Luddenham Advanced Resource Recovery Centre Submissions Report

Prepared for Coombes Property Group & KLF Holdings
May 2021

Submissions Report

J190749 RP38

APPENDIX C -PRELIMINARY CONCEPT
ELIZABETH DRIVE/ADAMS ROAD INTERSECTION

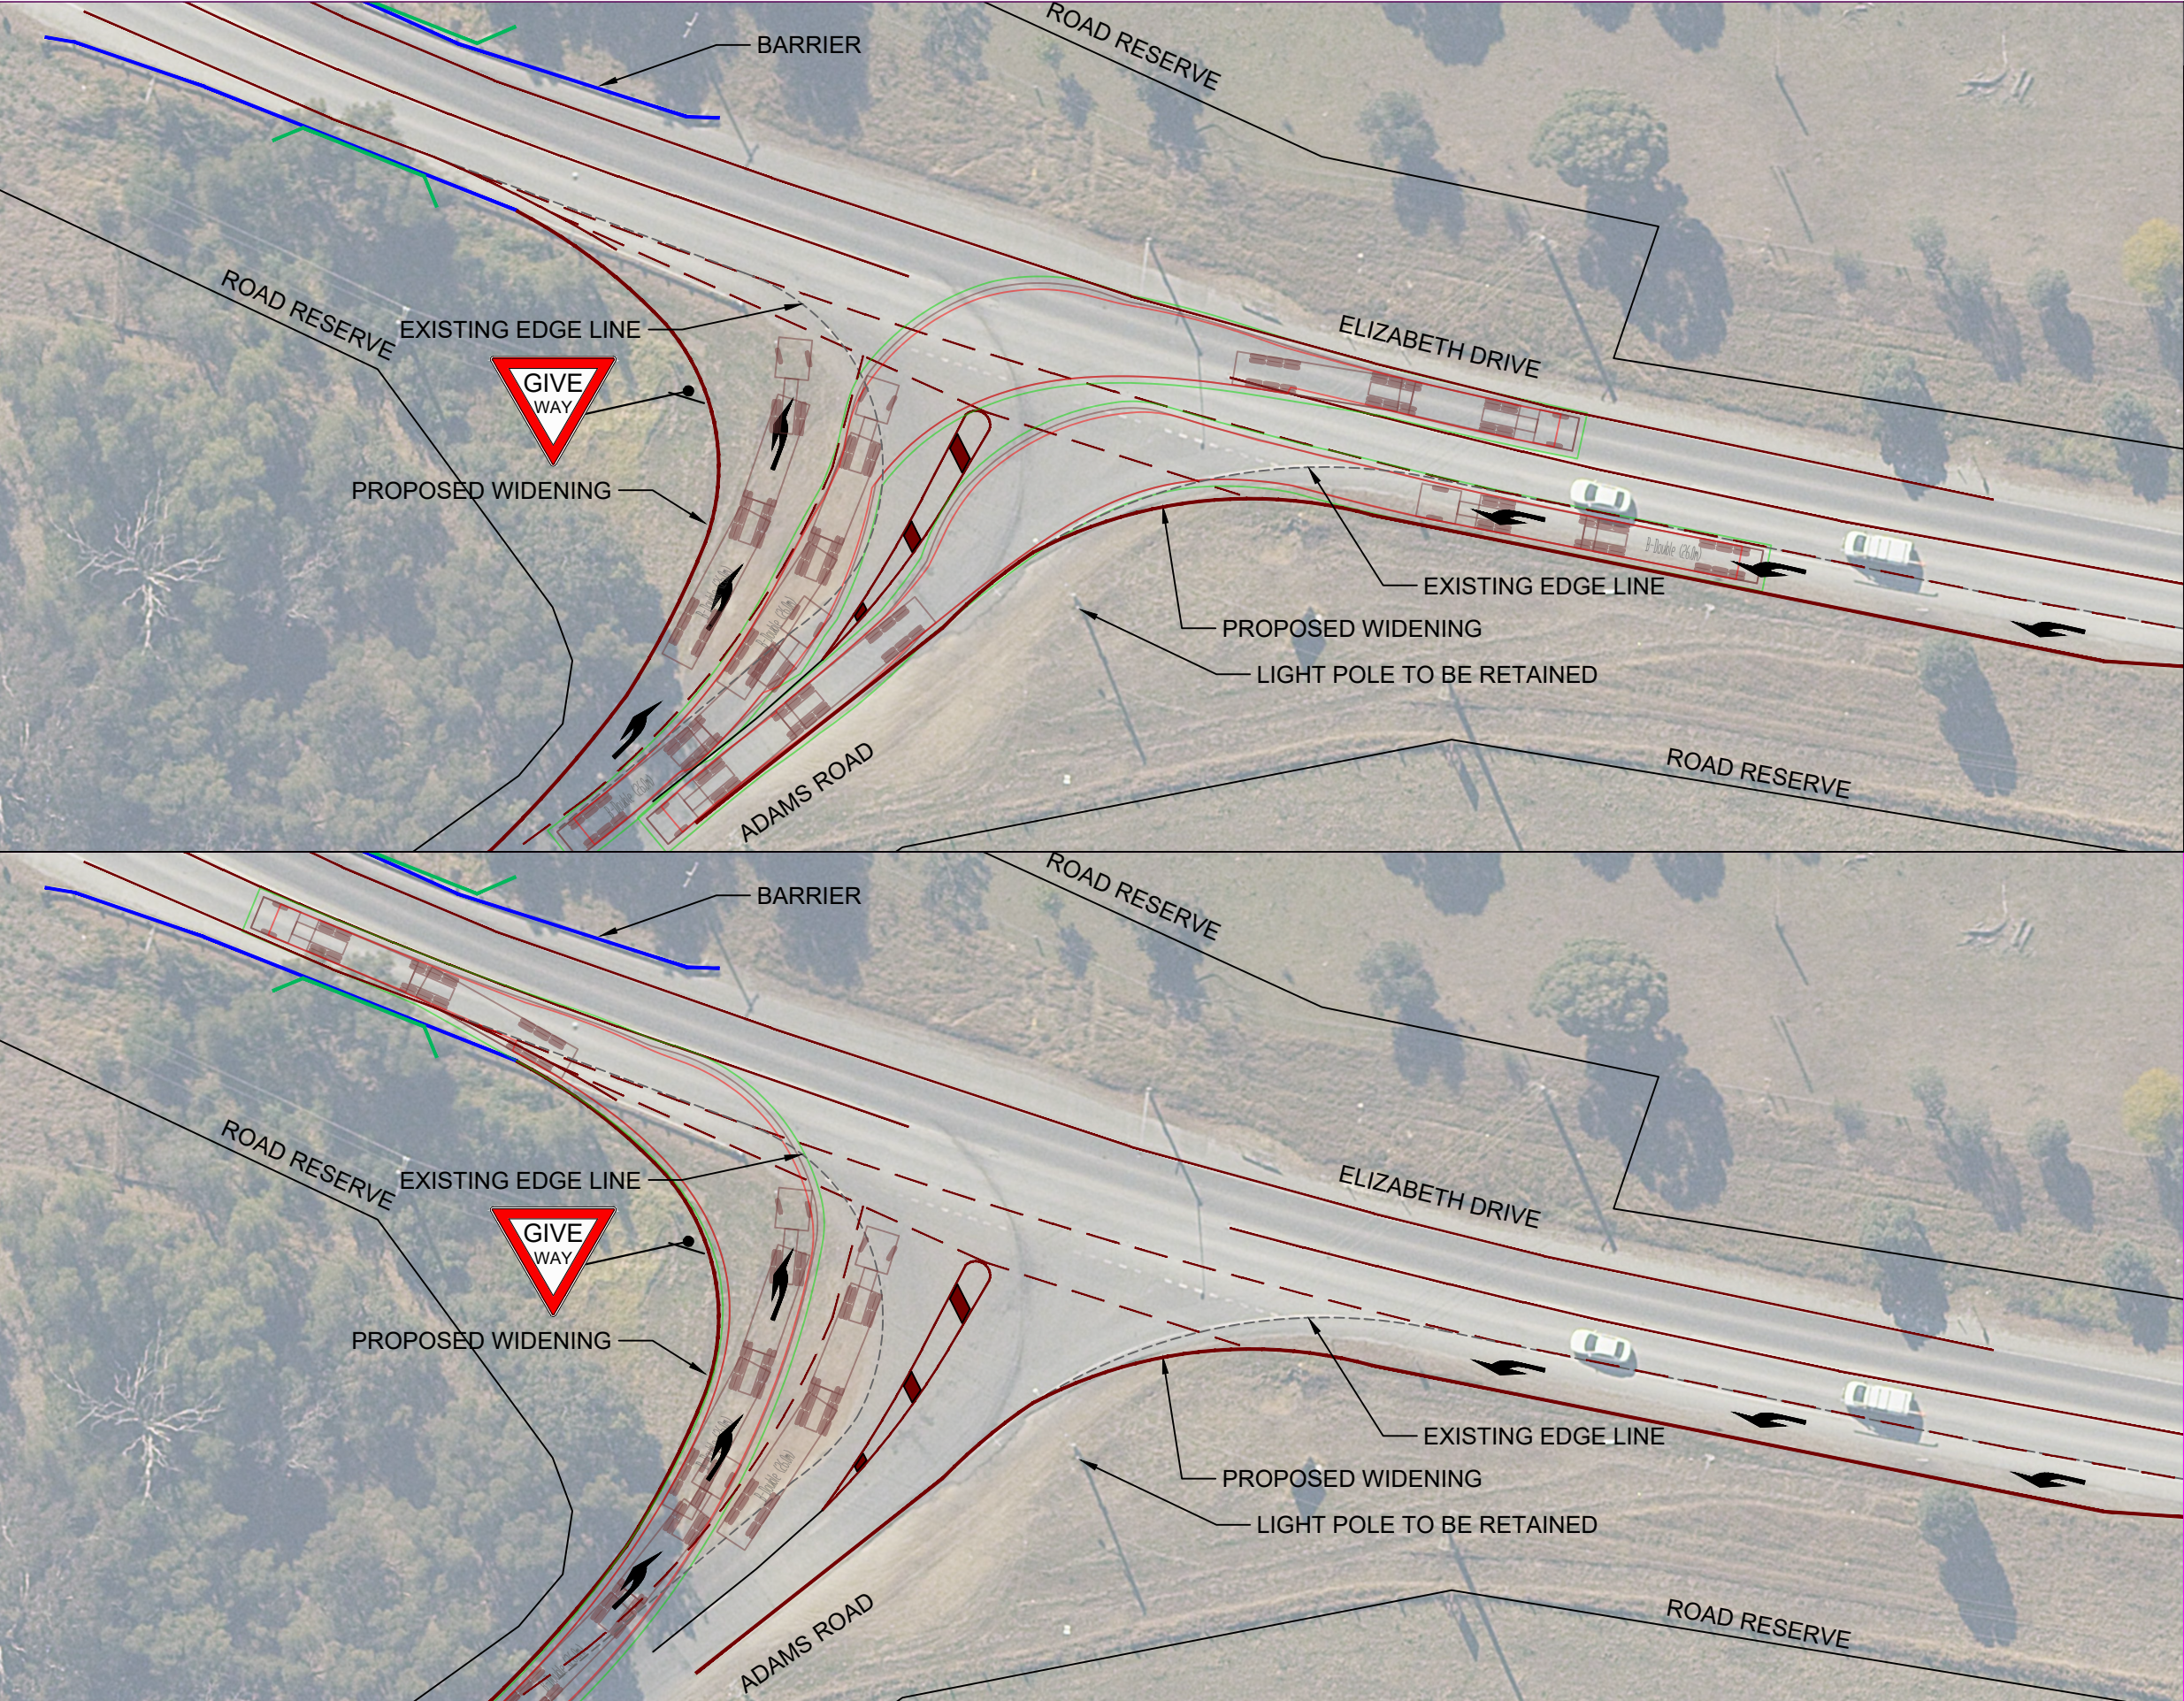
Consultation with TfNSW and Liverpool City Council has continued since the submission of the EIS. TfNSW raised safety concerns in relation to the right hand turn for heavy vehicles into Adams Road from Elizabeth Drive.

- Upgrade of turn treatments at the Elizabeth Drive/Adams Road intersection and restriction of the right-hand turn from Elizabeth Drive west into Adams Road as follows (refer preliminary concept sketch in Appendix C):

- provision of a 90 m deceleration left-hand turn lane into Adams Road to meet the Austroads guidelines;
 - provision of short left hand turn lane on Adams Road into Elizabeth Drive to minimise queuing on Adams Road;

- widening of existing Elizabeth Drive/Adams Road intersection to accommodate B-double swept paths; and
 - prohibiting the right-hand turn from Elizabeth Drive west into Adams Road for inbound ARRC vehicles –requiring these vehicles to access the ARRC using The Northern Road and the Adams Road south of the ARRC.
